Martin Nugent
01254 828060
D3/12/0786

**Planning Application, Ribble Valley District
D3-12-0786 Clitheroe Hospital, Chatburn Road, Clitheroe**

My comments relate to a full Planning Application for the development of a new Community Hospital and make reference to the Transport Assessment (dated August 2012) prepared by Royal Haskoning UK and the Design and Access Statement (July 2012) prepared by Nightingale Associates on behalf of the Eric Wright Group.

DRAWING No.	9X5278 SK003	REVISION
-------------	--------------	----------

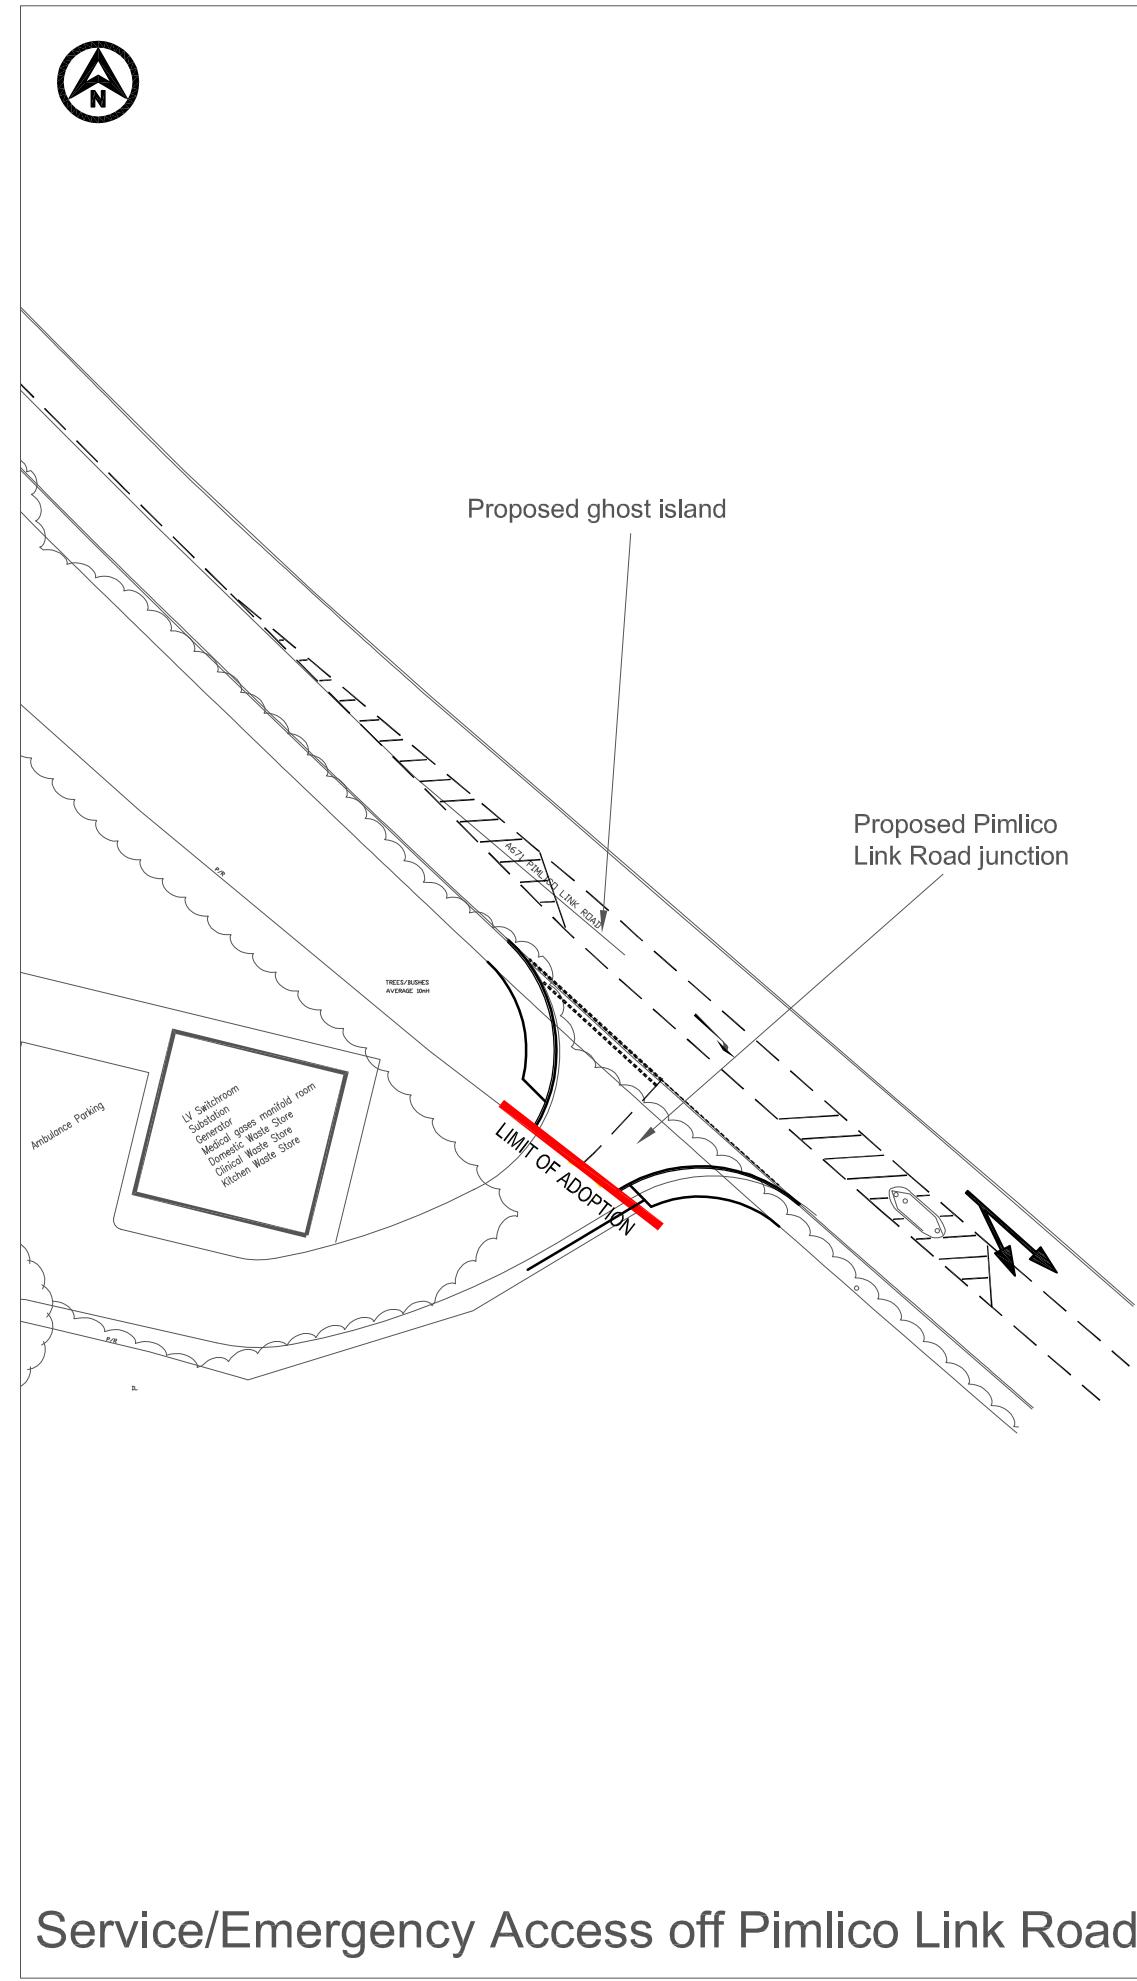
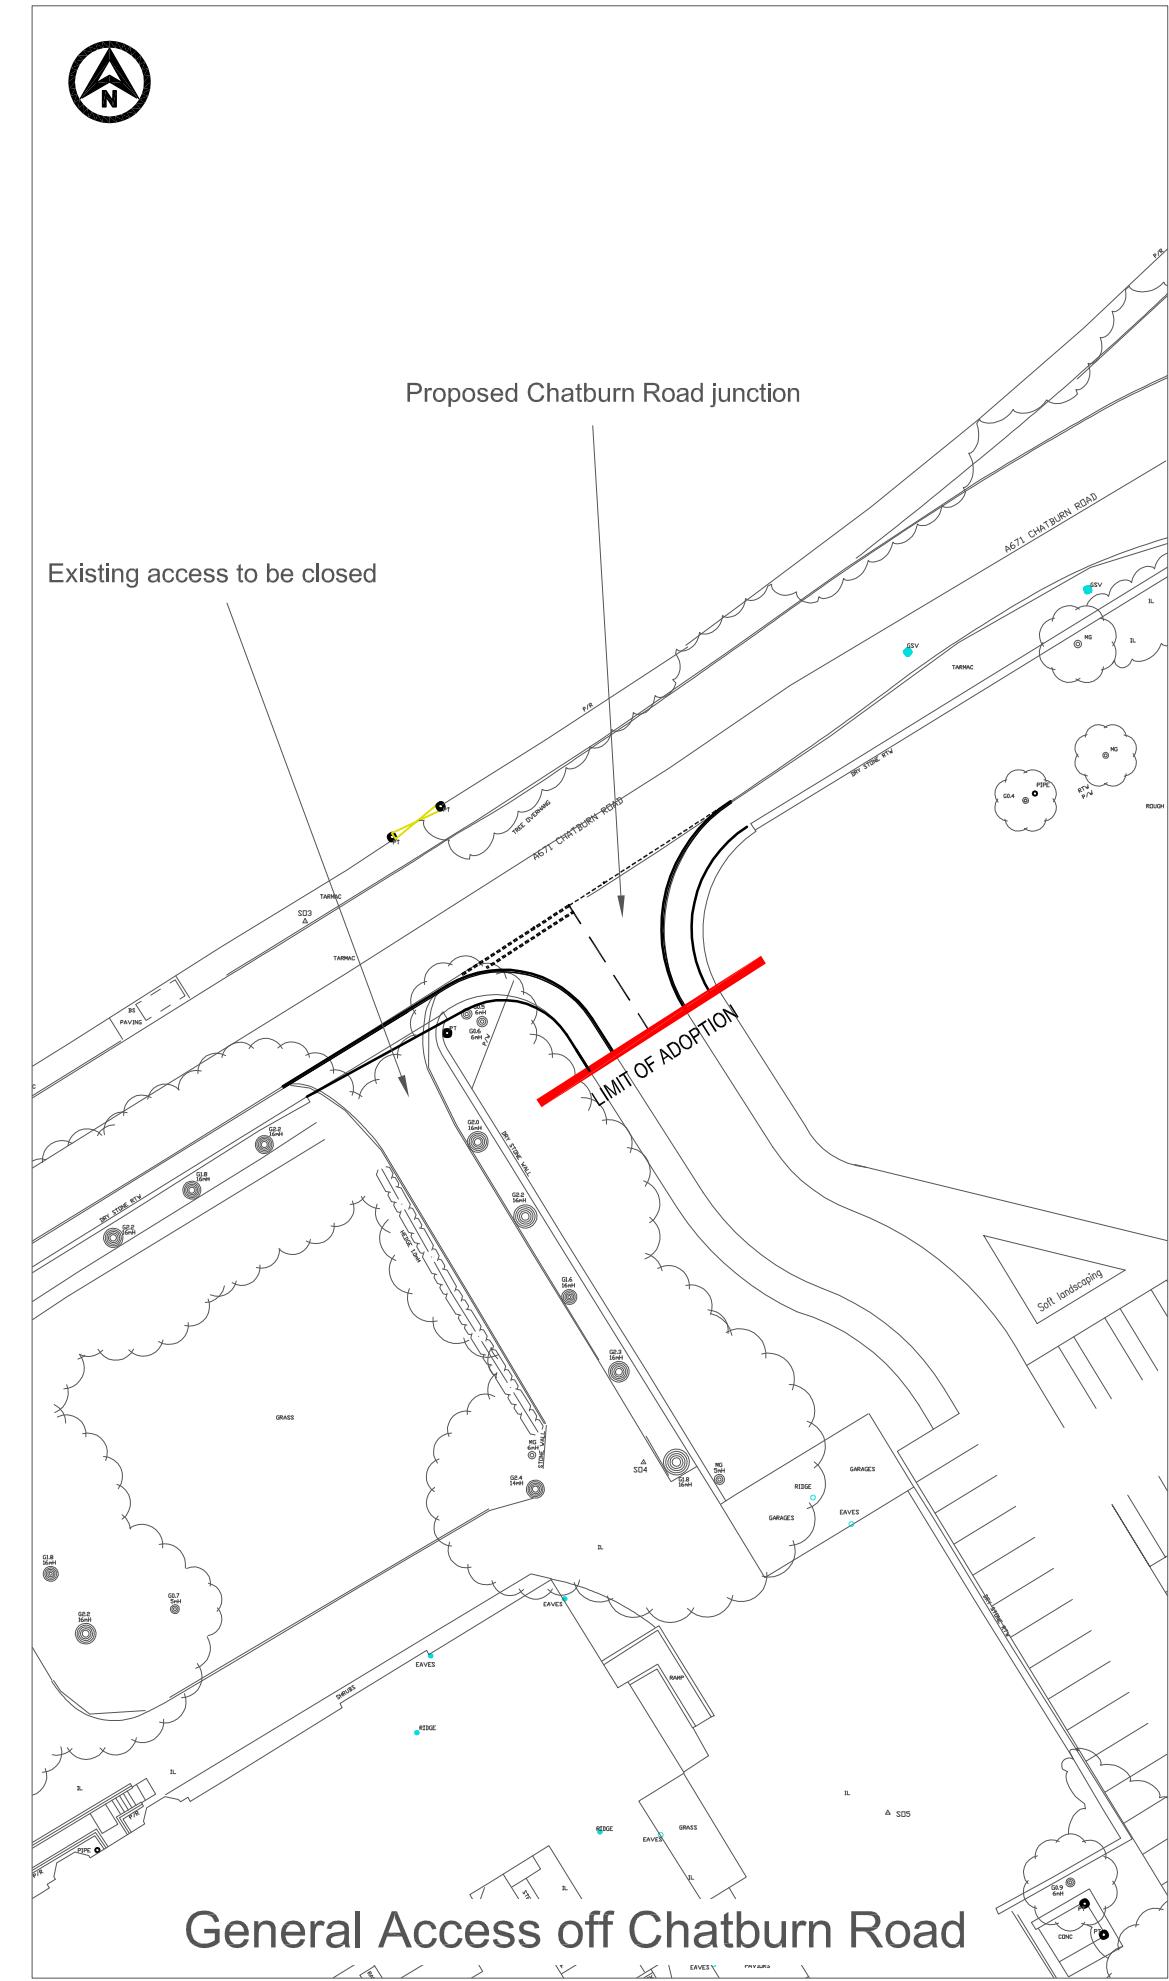
Both of these vehicular accesses to the site will be developed from existing field gates to the site from Chatburn Road and Pimlico Link Road. The designs contained in Plan 6 - Drawing 9X5278 SK001 provide an acceptable range of highway parameters for the design of suitable vehicular accesses.

The proposed limits of adoption on the hospital access roads are clearly indicated. However, the construction of the remaining lengths of access road must be to a suitable standard to maintain safe access for motorists and pedestrians.

Plan 6 does not identify any specific street lighting provisions. There is an existing lighting column to the south west of the proposed entrance and the suitability of retaining this column and the additional requirements that would be appropriate should be identified.

The inclusion of any additional street lighting provisions will be considered as part of the S278 process.

DRAWING No.	9X5278 SK002	REVISION	A
-------------	--------------	----------	---

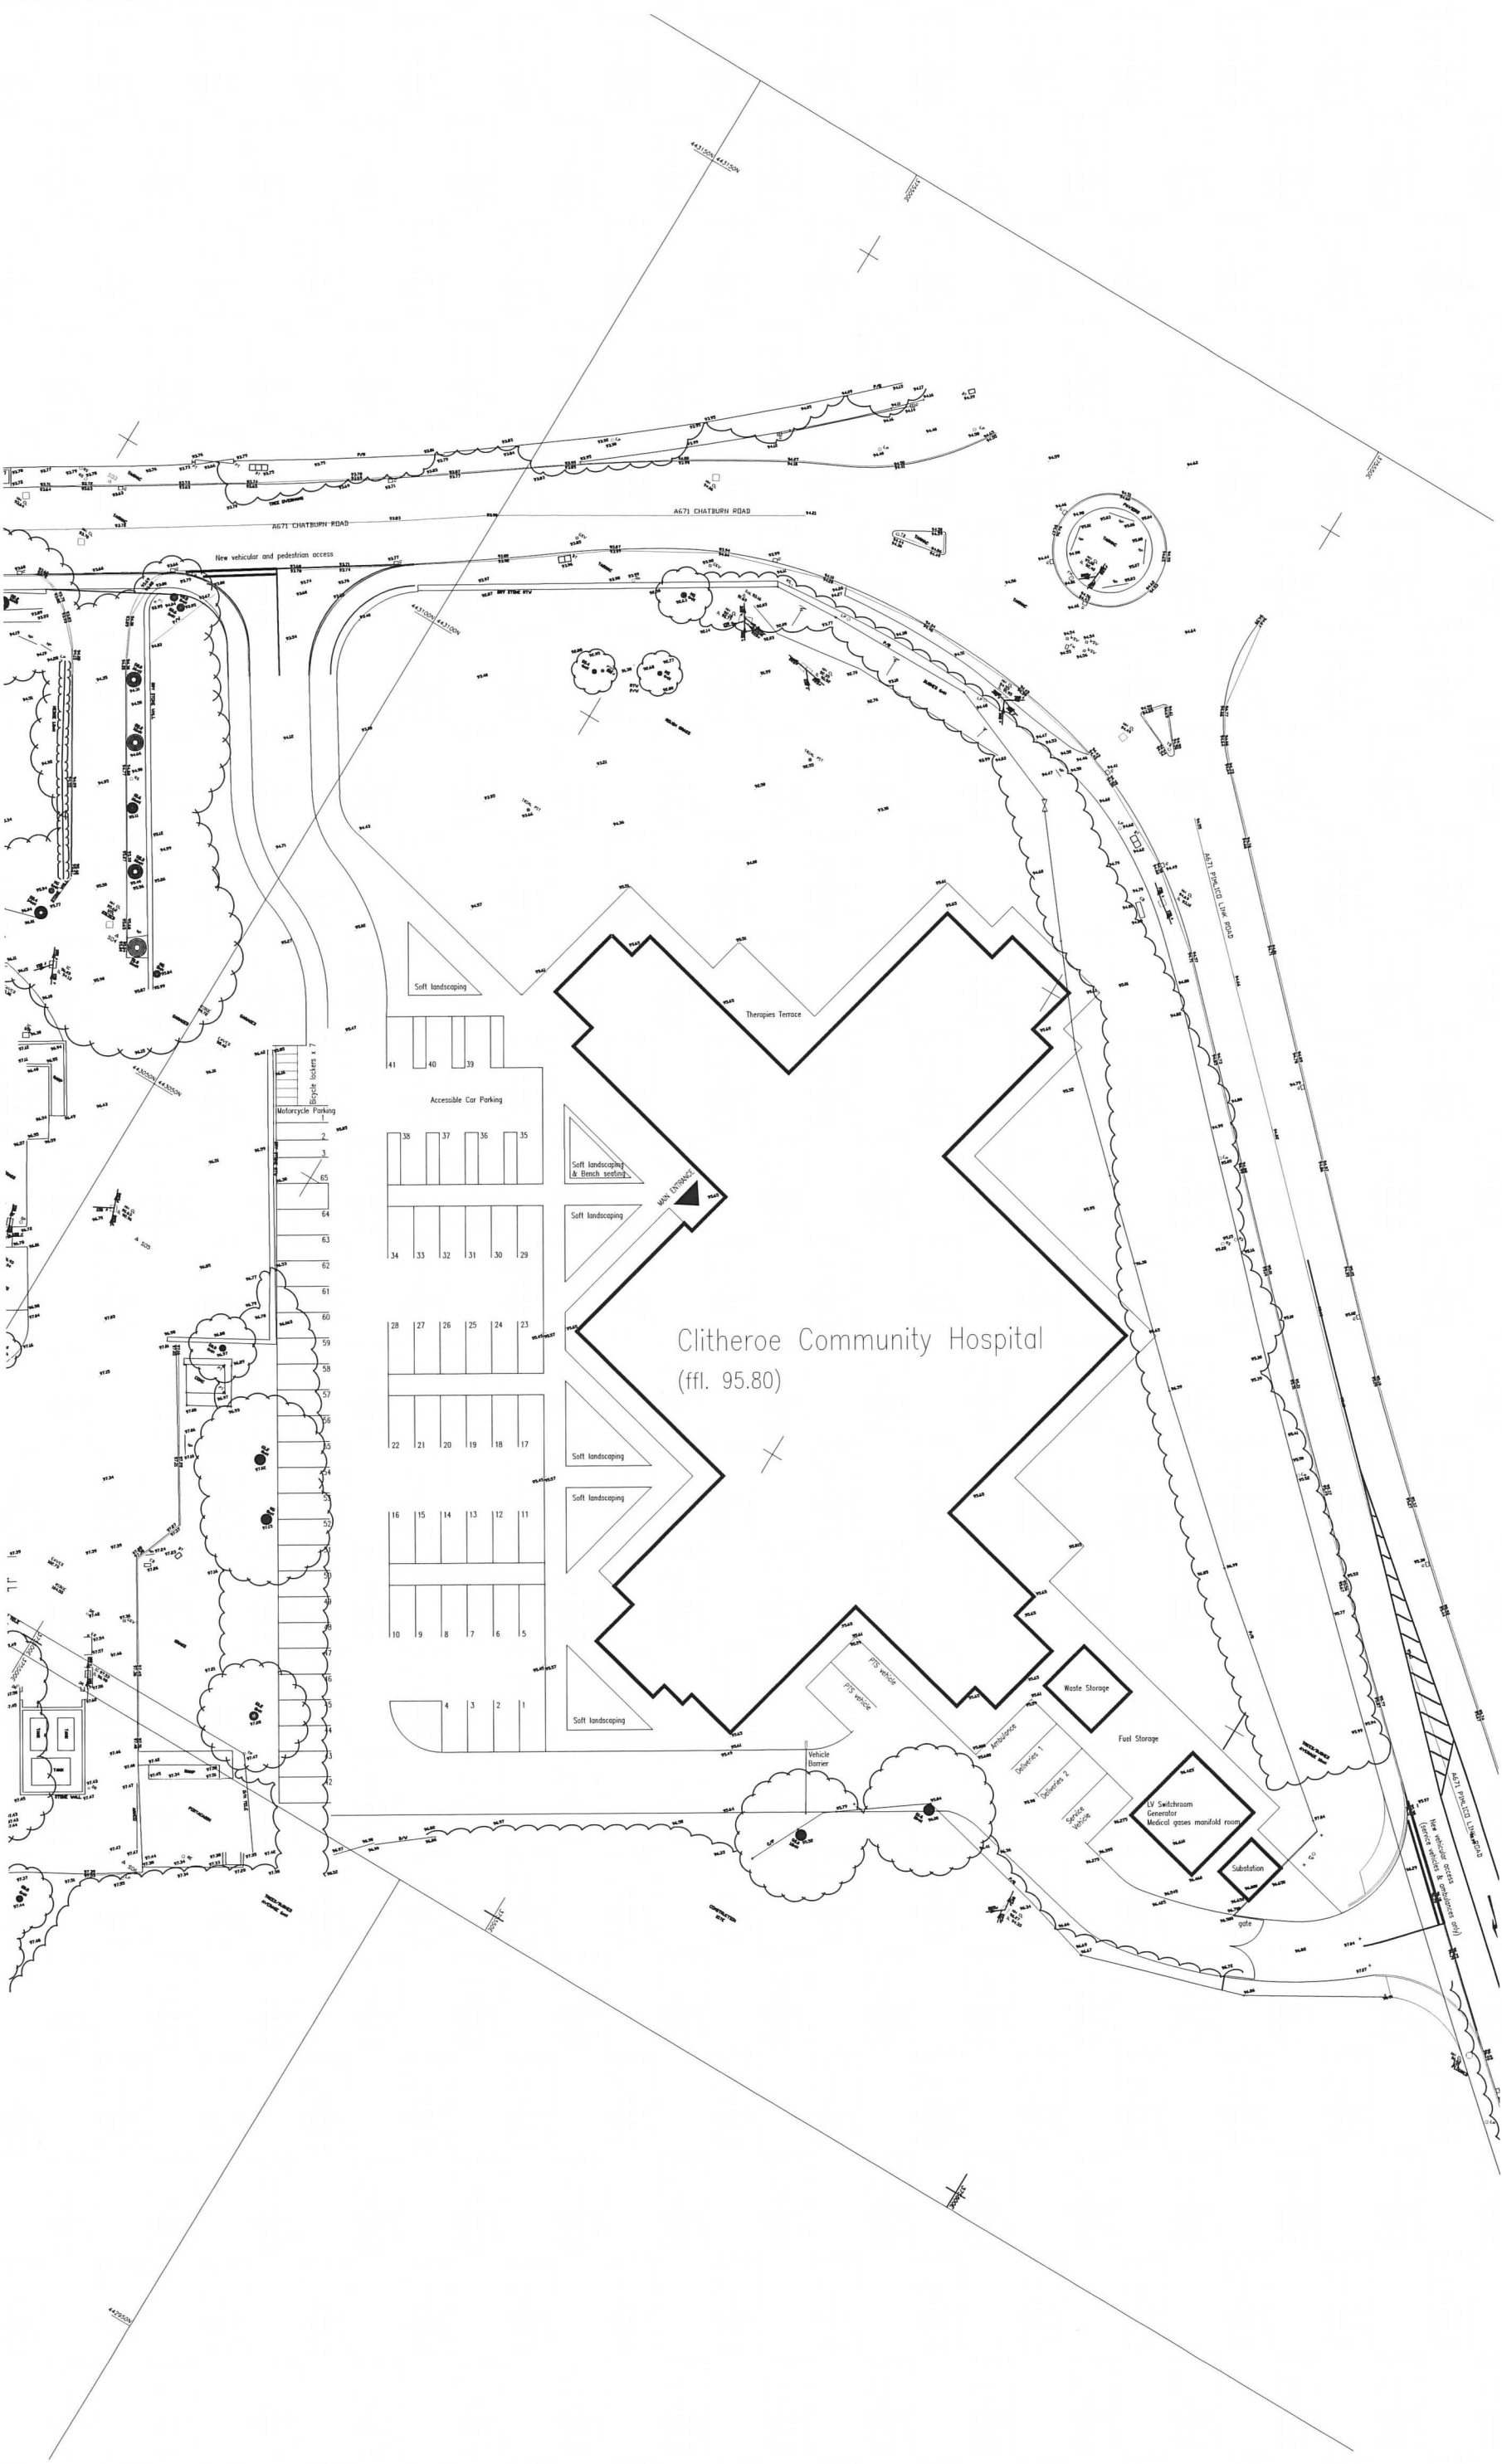
With this in mind, I have no objection to the levels of parking provision identified in the application and the internal layout shown on the site plan, Drawing AR WS XX PL 100 005 Rev B and Plan 6 - Drawing 9X5278 SK001.

The only revision I would recommend concerns the layout of the markings for the first designated disabled parking space. The yellow hatching to the side of the space should face the access road, to provide additional protection for the affected individual, either the driver or passenger, to access their vehicle safely and
